PLANNING CONSULTATION RESPONSE

Application No	2026/0543
Proposal	Change of use of land to Gypsy and Traveller Site with associated caravan and day room (Part Retrospective)
Address	Land at Shaftesbury Street, Stairfoot, Barnsley S70 3PU
Date of Consultation Reply	9 th October 2026
Consultee	Highways DC

[3rd response]

PROPOSED SITE PLAN SCALE 1:100

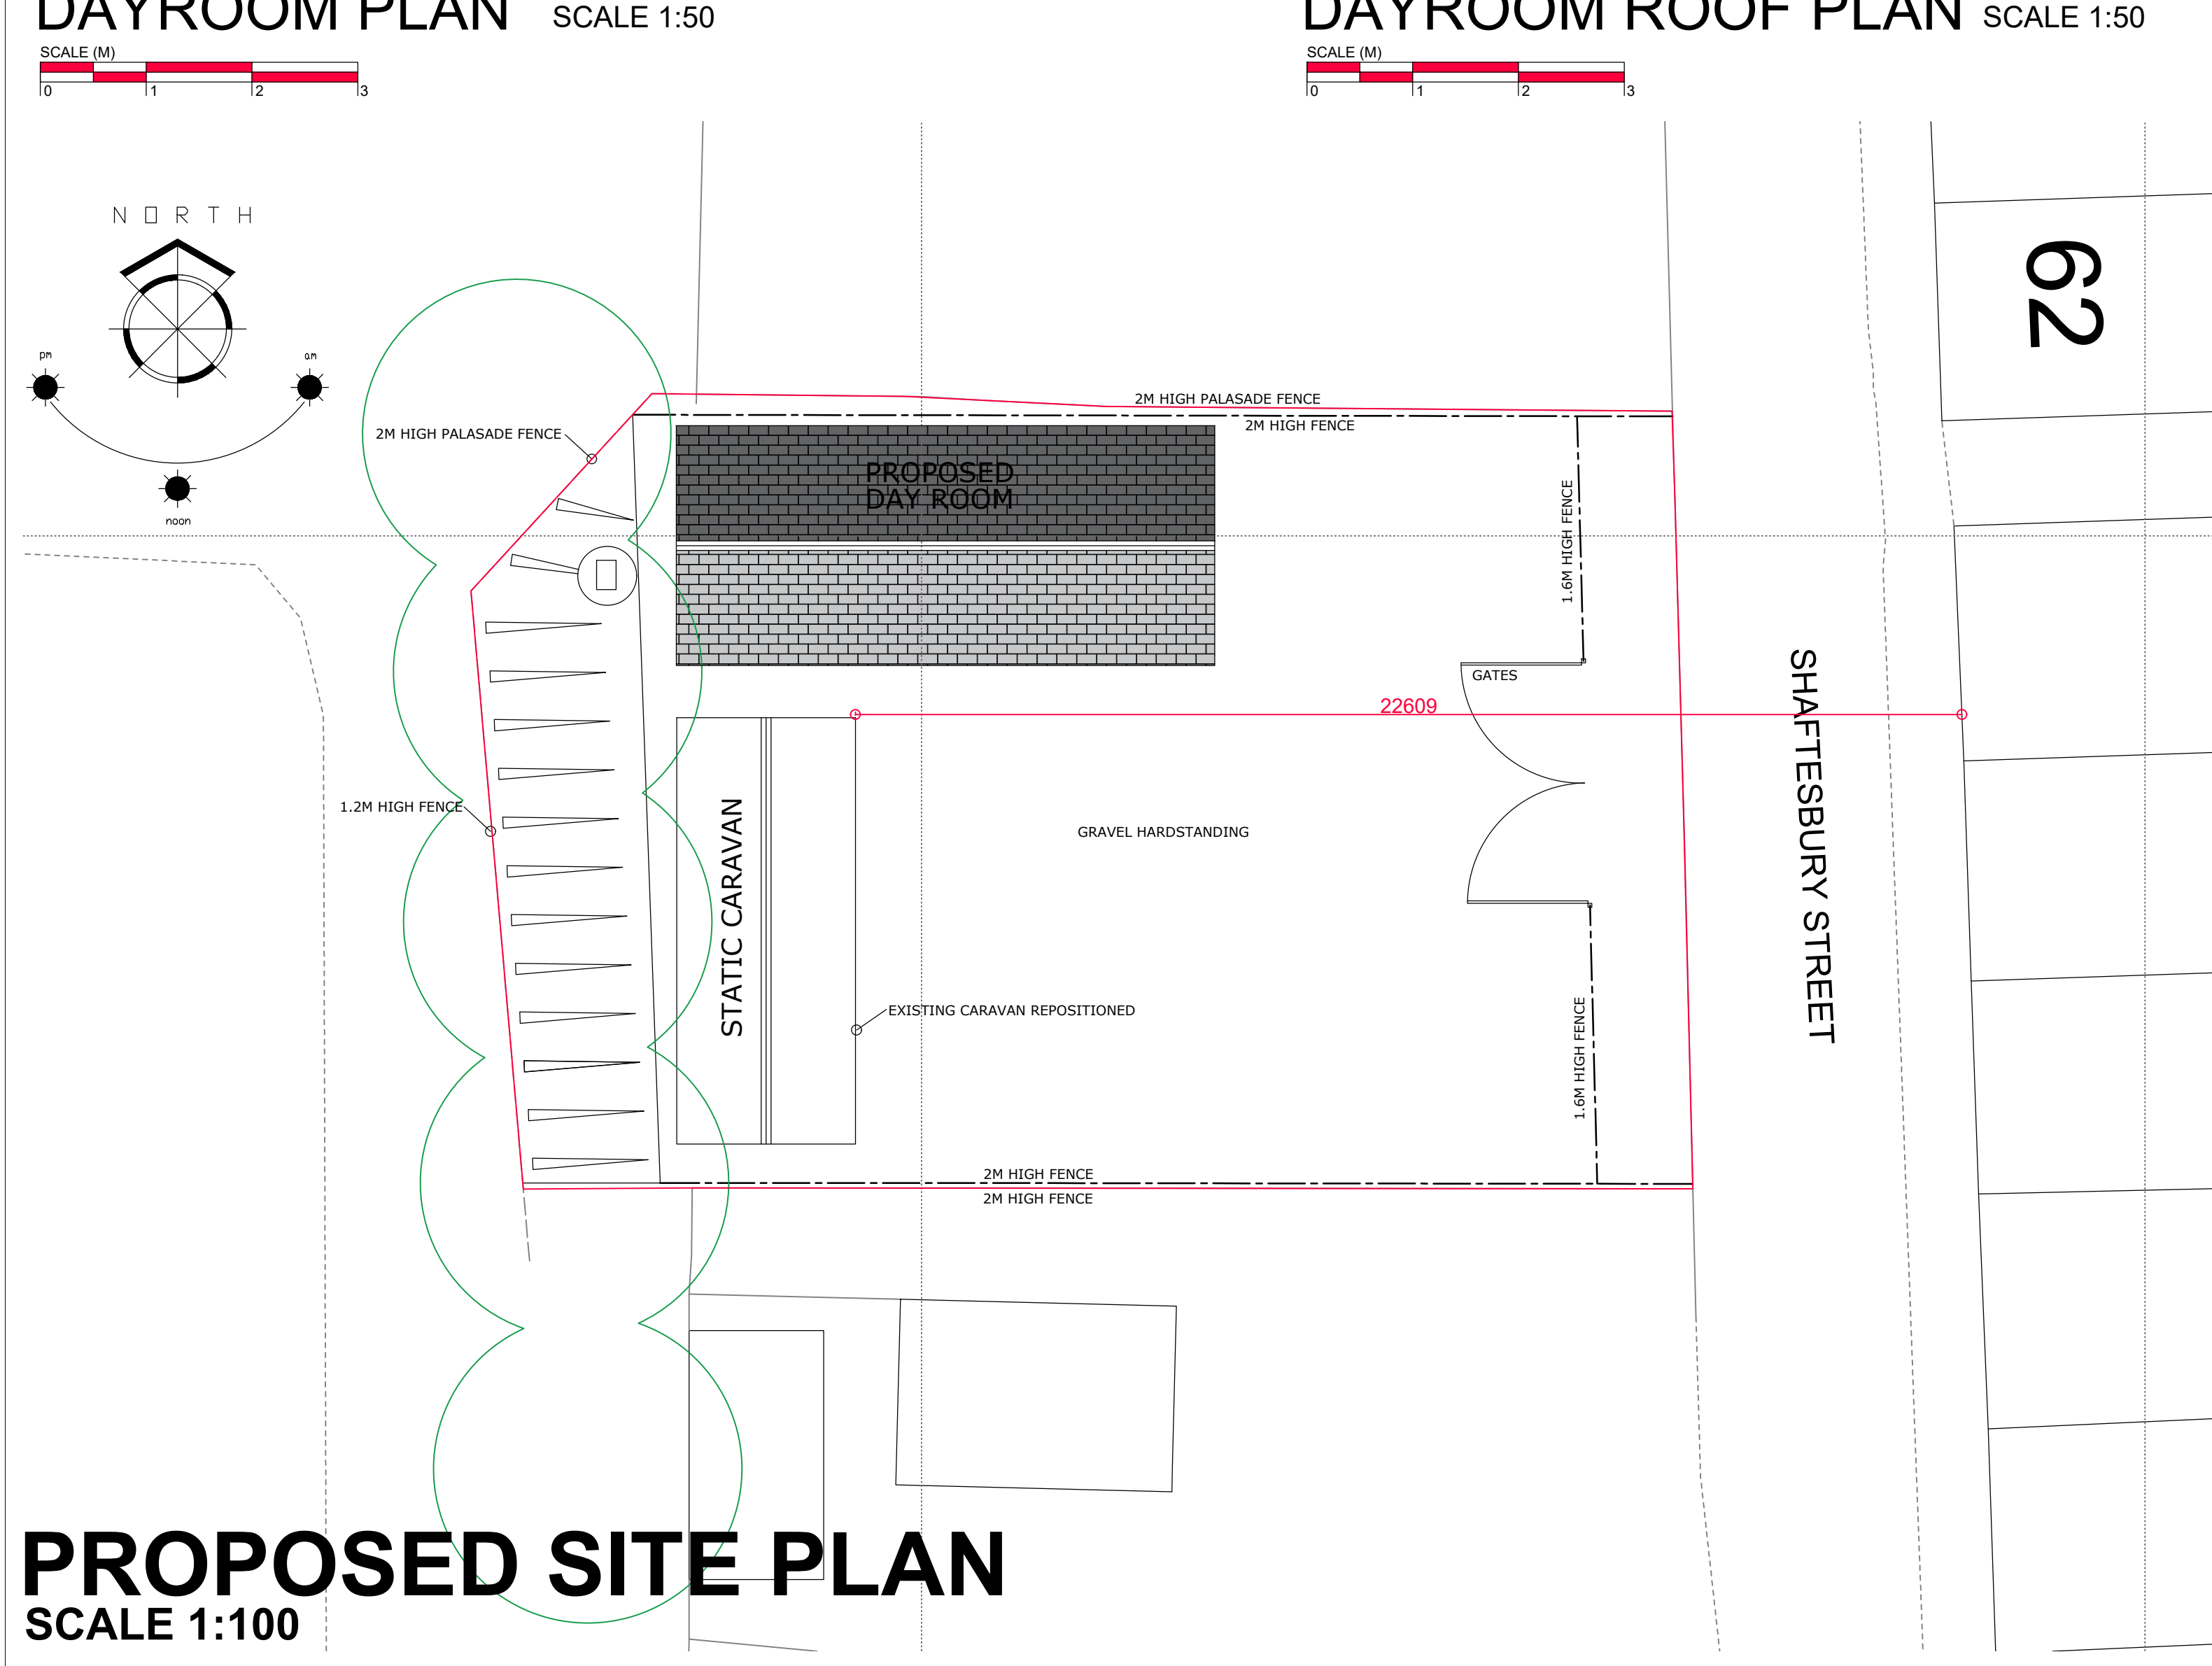
As mentioned in my initial response, it is evident that vehicles parked on-street commonly occupy much of the footway, thereby forcing pedestrians to walk within the carriageway. However, the proposals include ample parking provision within the site and do not therefore result in an increase in on-street parking.

Likewise, the proposals would not adversely impact upon the existing situation in terms of accessibility for emergency service vehicles. From the position that a fire appliance would park when attending any property, it should be within 45m of all parts of that dwelling; these proposals satisfy that requirement.

All areas within the site to be used by vehicles shall be surfaced in a solid bound material (i.e. not loose chippings) prior to the development being brought into use and shall be retained for said purpose at all times. Adequate measures shall be so designed into the proposed vehicular areas to avoid the discharge of surface water from the site on to the highway.

Sight lines, having minimum dimensions of 2.4m x site frontage shall be provided at the access junction with Shaftesbury Street, such that there is no obstruction to visibility at a height exceeding 1.0m above the nearside edge of the adjacent highway. Nothing shall be erected, retained, planted and/or allowed to grow at or above a height of 1.0m which would obstruct the sight lines and they shall be maintained free of obstruction at all times thereafter for the lifetime of the development.

Prior to the development being brought into use, the vehicular access shall provide pedestrian visibility splays of 2m x 2m to the back edge of the footway/verge. Nothing shall be erected, retained, planted and/or allowed to grow at or above a height of 0.6m to the rear of the footway/verge which would obstruct the visibility splays. The visibility splays shall be maintained free of obstruction at all times thereafter for the lifetime of the development.

Any gates shall be designed to only open inwards and be permanently retained as such.
